Mr P Jefcoate  
Case Officer, Planning Department  
Welwyn Hatfield Borough Council  
The Campus  
Welwyn Garden City  
Hertfordshire  
AL8 6AE

23<sup>rd</sup> May 2010

**AMENDMENT TO PLANNING APPLICATION S6/2008/1652/FP TO REPLACE FIRST FLOOR REAR WINDOW TO DOORS AND ADDITION OF RAILINGS TO FORM JULIET BALCONY at 93 The Ridgeway Cuffley Potters Bar**

Rear Section/Elevation

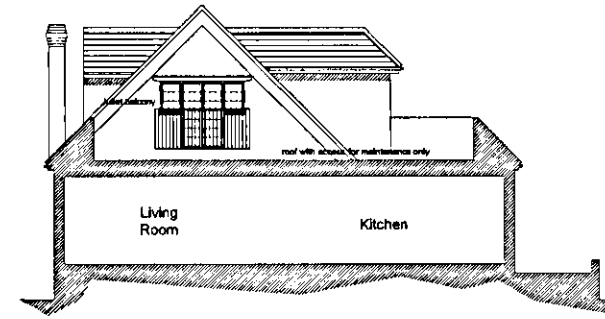
As this is an amendment, could I ask you to consider the following preconditions, and include them to form part of the approval agreement, if your decision is to approve this amendment.

The Juliet Balcony is made of a one piece construction with no moving parts, e.g.hinges for a gate that could open.

The Juliet Balcony is not allowed to fall into a state of disrepair.
